Re: Stripes on Wyoming
2505 Wyoming Blvd NW
Traffic Circulation Layout
Engineer's/Architect's Stamp 12-2-19 (H19D049)

Based upon the information provided in your submittal received 12-3-19, the above referenced plan cannot be approved for Building Permit until the following comments are addressed:

2 TCL REMODELED SITE PLAN

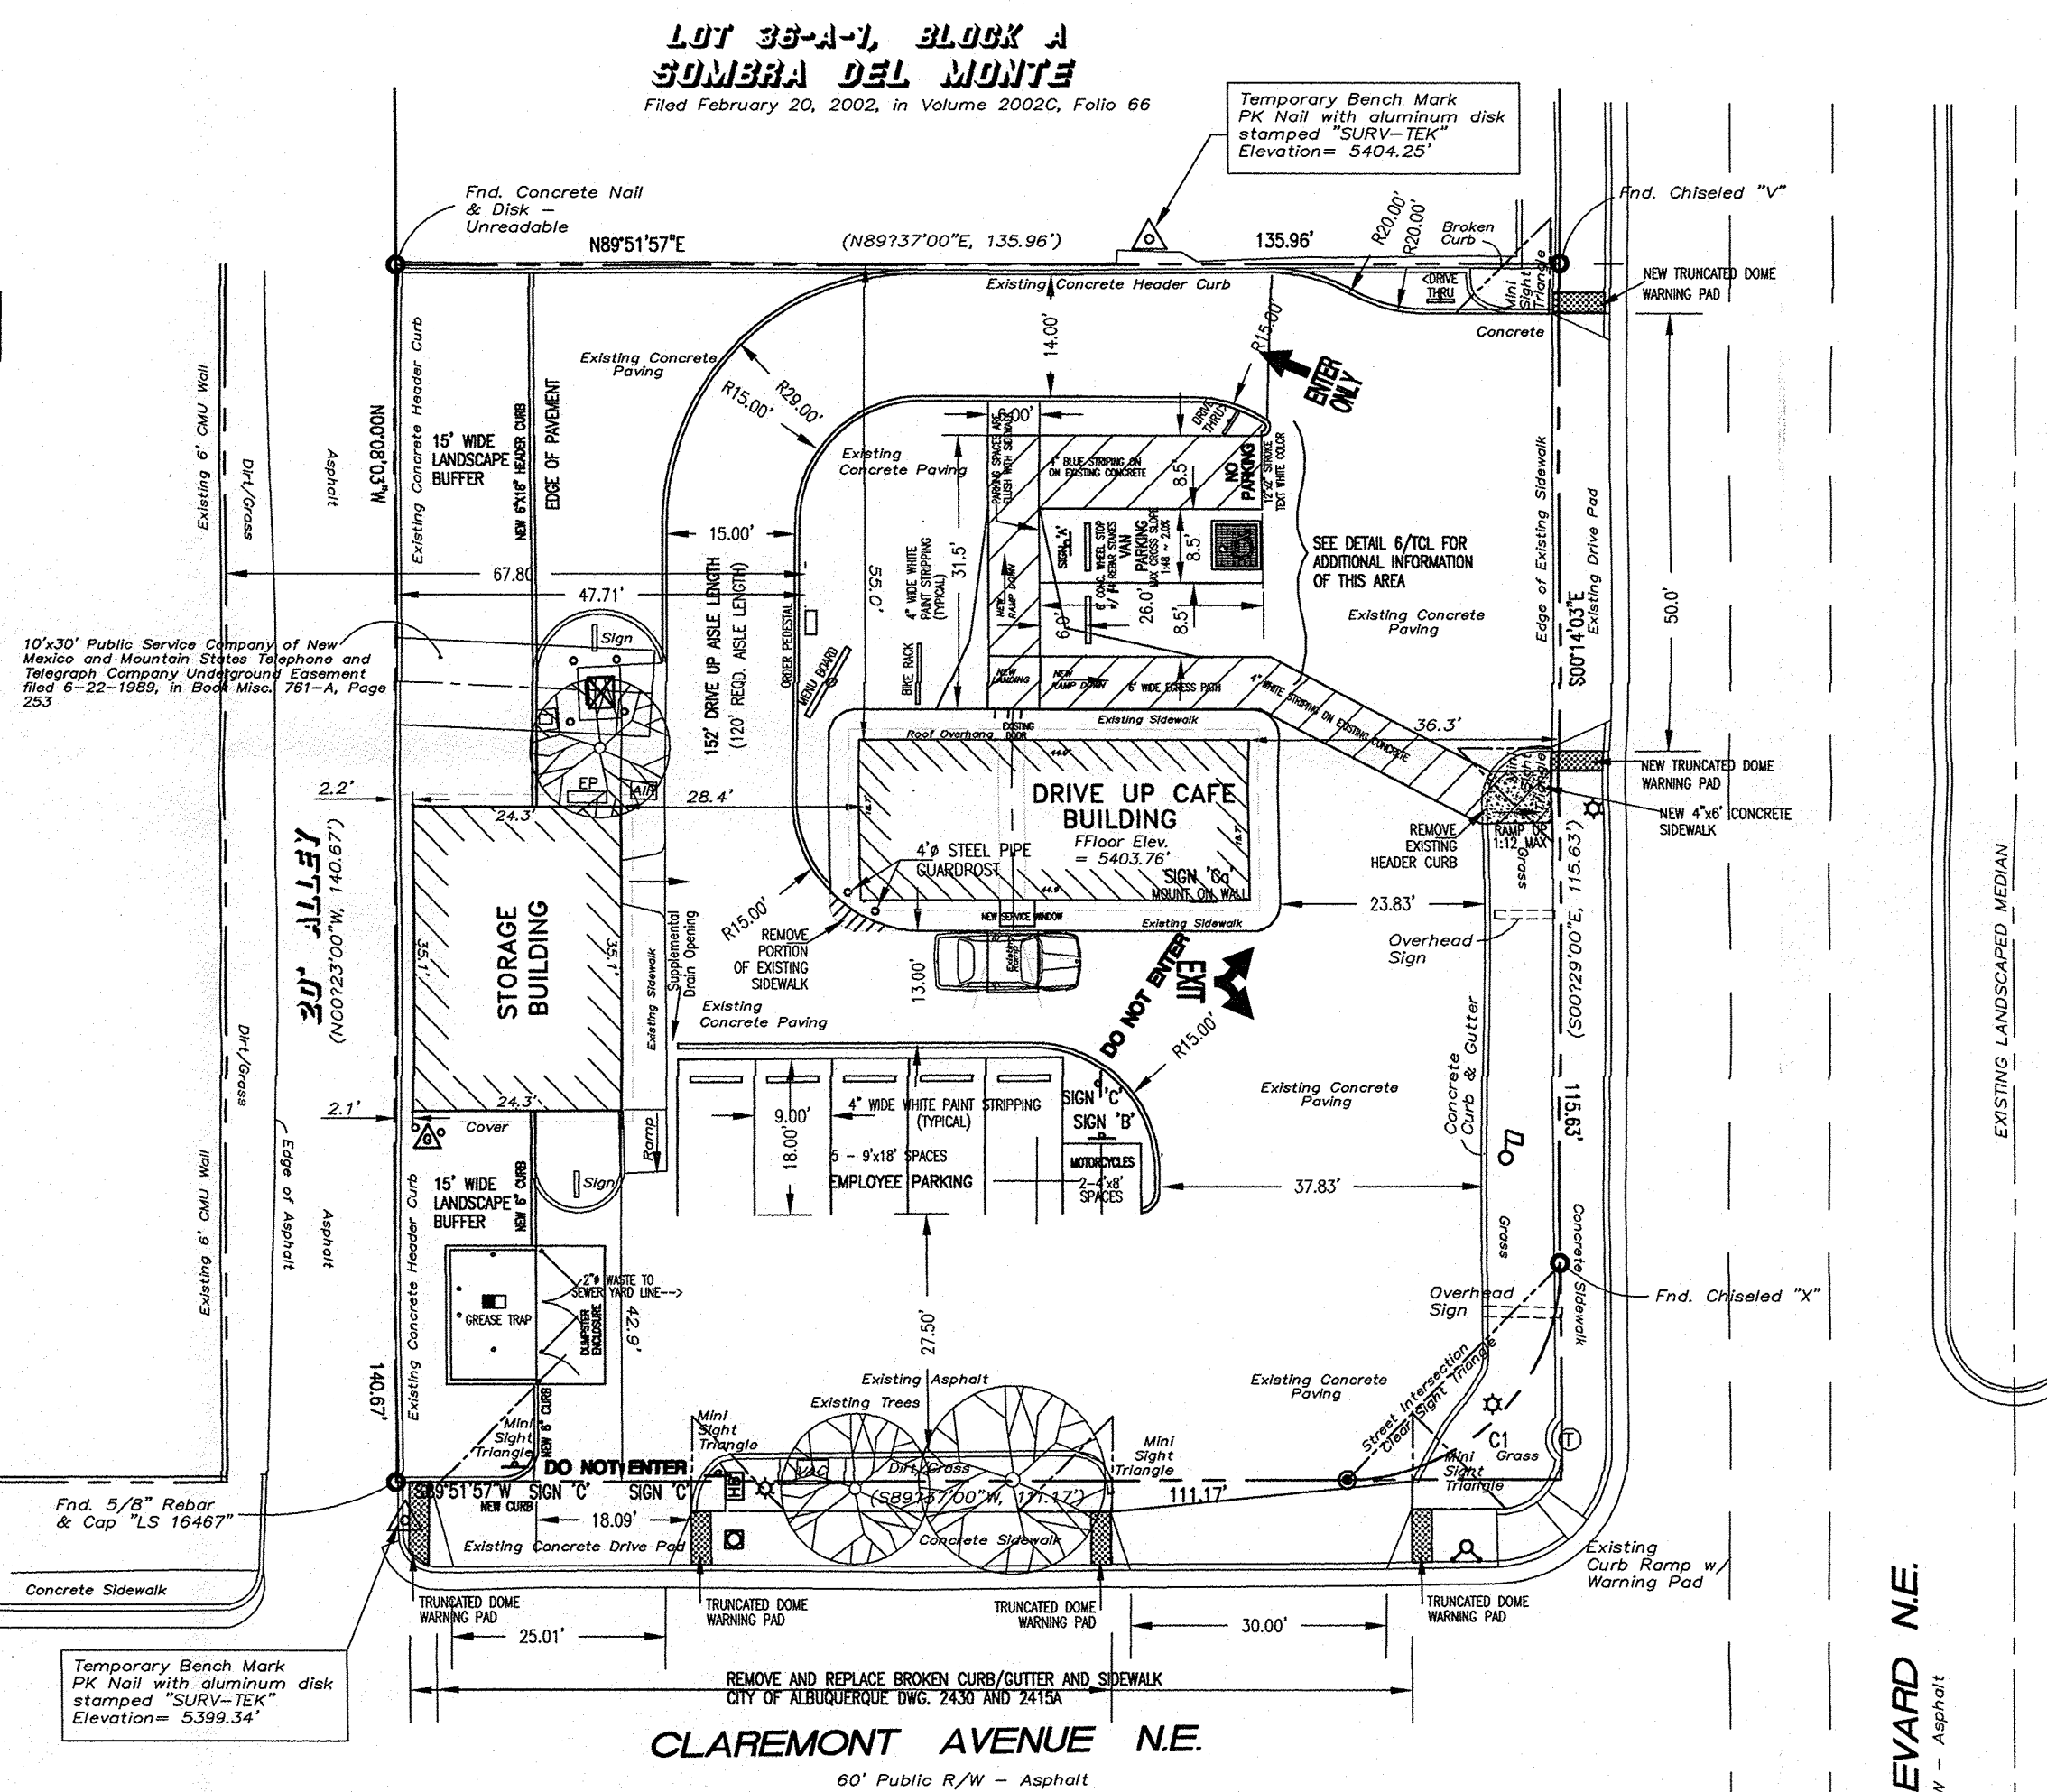
1. Per the IDO, a 6 ft. wide ADA accessible pedestrian pathway is required from the public sidewalk to the building entrances. Please clearly show this pathway and provide details. (Path provided indicates 5')

2. Please indicate running and cross slopes on existing ramp. (8.0 % max running slope / 2.0% max cross slope. (Please update to ADA compliance)
3. Please correct Detail 6/TCL ACCESSIBLE PARKING AREA to match TCL site plan. (Parking Clacs may need adjustment after correction.)

4. Remove raised concrete curb on top of side walk (Access of Wyoming) (Add detail if modifying the drive apron and sidewalk)
5. Service vehicle and/or refuse vehicle maneuvering must be contained on-site; provide a copy of refuse approval.

6. Please remove existing ramp at service window.
7. Please correct signage for motorcycle parking. (Plan indicates Sign A, ADA parking)
8. One-way vehicular paths require pavement directional signage and a posted "**Do Not Enter**" sign at the point of egress. Please show detail and location of posted signs. (Please add Do Not Enter at exit only access off Claremont Ave) (Please add signs and floor markings at drive through exit.)

9. Please provide a sight distance exhibit.
10. Show the clear sight triangle and add the following note to the plan:
"Landscaping and signage will not interfere with clear sight requirements. Therefore, signs, walls, trees, and shrubbery between 3 and 8 feet tall (as measured from the gutter pan) will not be acceptable in the clear sight triangle."

11. Add a note stating "All broken or cracked sidewalk must be replaced with sidewalk and curb & gutter." A build note must be provided referring to the appropriate City Standard drawing.
12. Add a note stating "All wheelchair ramps located within public right of way must have truncated domes"
13. Please add direction arrows throughout site and add detail.
14. Please include one copy of the traffic circulation layout at the next submittal.
